The Furnace, Ipswich

Initial Concept Review - Notes

10 May 2023

EXISTING: FLOOR PLANS

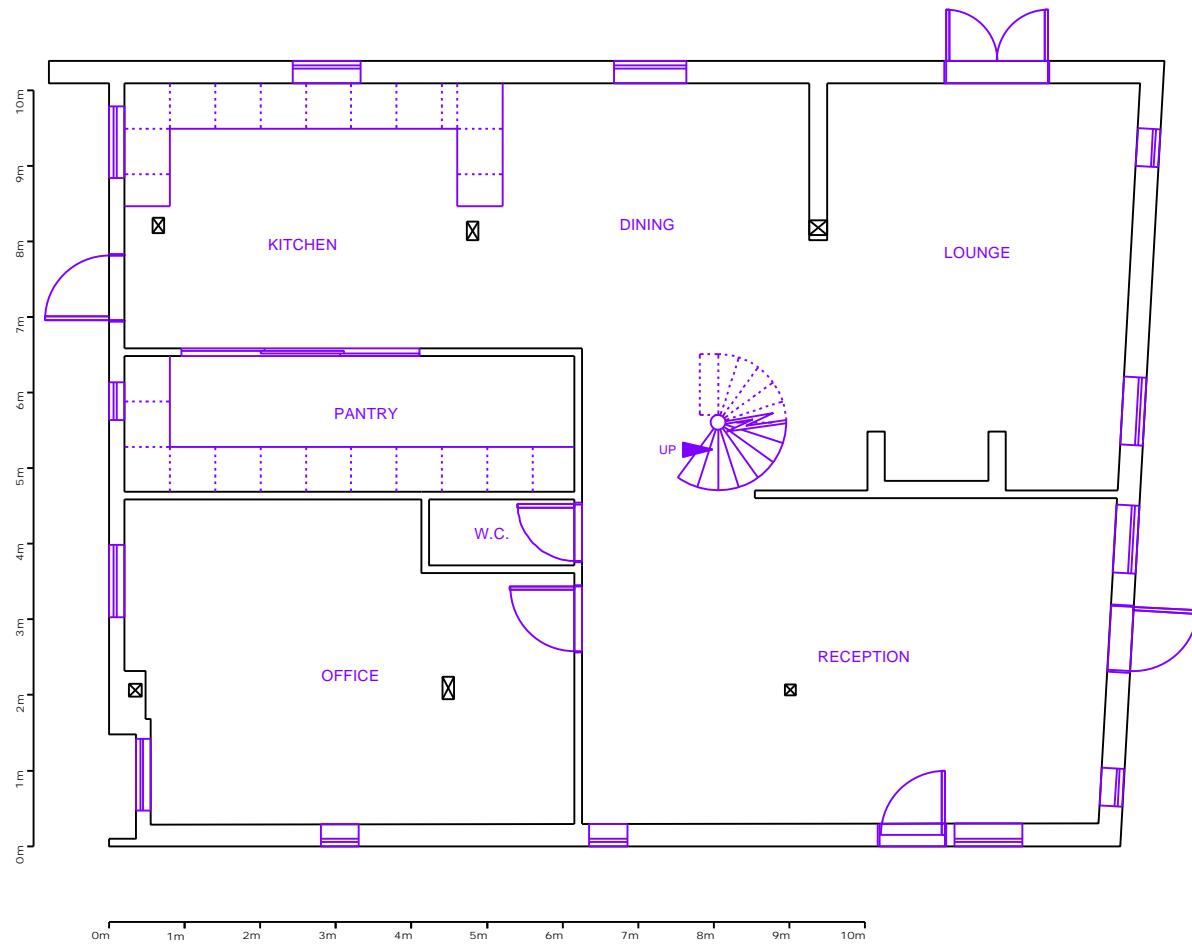
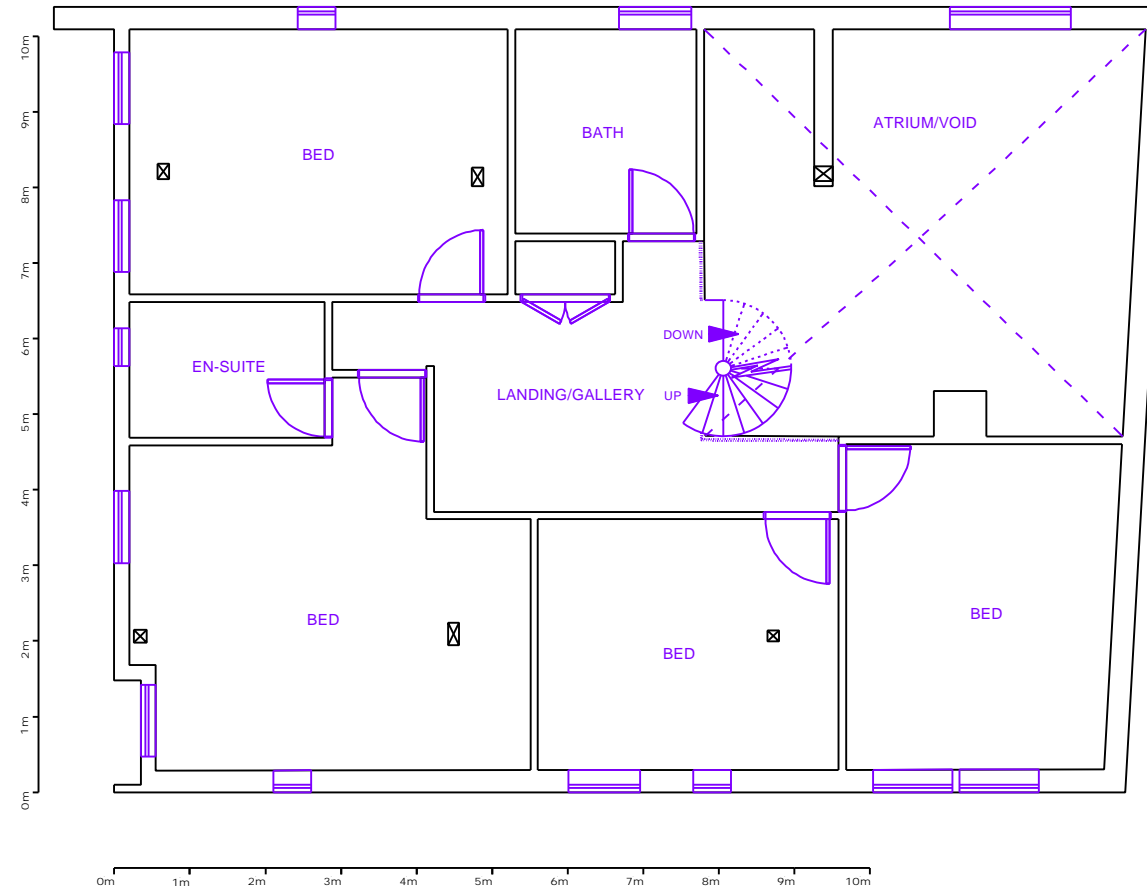
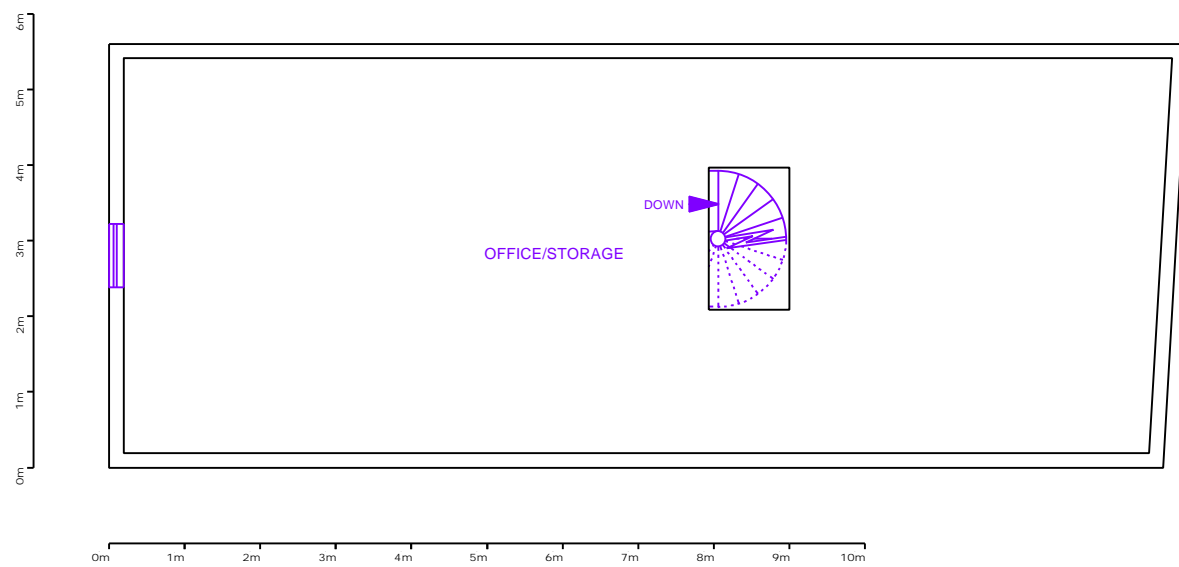
- 1.1.1 Two options appear to be available to accommodate the combined open plan arrangement at ground and first floor levels, with the provision of loft accommodation while preserving the open plan ground floor and atrium arrangement. These are:
1. To provide an alternative escape route from the second floor accommodation via a new external escape stair.
 2. To provide a protected escape route from the second floor via an internal stair to the first floor, to enable the occupants of the second floor accommodation to access an escape window on the first floor, without needing to enter the open plan ground floor/atrium space.

1. No fire compartmentation is required, but all floors should be provided with 60 minutes of structural fire protection, measured from the underside.
 2. Sprinklers are required throughout the premises, to Category 1, BS9251: 2021.

3. An automatic fire detection and alarm system is required throughout the premises to Category LD1, BS5839-6.
 4. The ground floor office should have a separate exit to avoid inner room situation. This can be an escape window or a full door.

5. All construction separating the habitable rooms from the gallery/atrium at first floor should provide a minimum of 30 minutes of fire resistance. Doors should have a minimum specification of FD20.

6. All habitable rooms on the 1st floor should have escape windows.

- 1.3.1 Option 1 will also require the following additional measures:
- The head of the existing spiral stair should be enclosed in fire resisting construction (30 mins).
 - A new escape stair should be provided from the second floor accommodation, which is separated from the rest of the accommodation by fire resisting construction providing a minimum of 30 minutes of fire resistance. This stair may be a spiral/helical stair if desired.
 - If the new stair is to be constructed as an external stair, all construction within 1.8m horizontally from the stair, and between 1.1m above the highest walking surface, and 9m below any part of the stair, should be fire resisting to a minimum of 30 minutes. Such fire resistance should be measured from the inside of the construction.

- Windows within this area should be fitted with suitable fire resisting glazing and fixed shut.
- It is understood that the inner surface of the external wall adjacent to the most likely location of an external stair is formed from lathe and plaster. When in good condition, it is generally accepted that this will provide 20 minutes of fire resistance. The level of fire resistance may be increase by the application of a suitable intumescent coating, such as Envirograf P105, or similar product.

- The ground floor accommodation should be separated from the route from the second floor to the first floor by fire resisting construction, to give the option for occupants of the second floor to use an escape window on the first floor, without having to pass through the space open to the ground floor.

- A method of achieving this would be to remove the existing spiral stair between the first and second floors and to install a new stair from the first floor accommodation to serve the second floor accommodation.

- The new stair should be accessed from the first floor gallery, but should also provide access to at least one of the first floor habitable rooms to allow the occupants of the second floor accommodation to access the escape window in the room as an alternative escape route, should the gallery/atrium area be compromised by smoke.

- The new stair should be separated from the first floor gallery and the bedroom providing the alternative escape route by 30 minute fire resisting construction and doors.
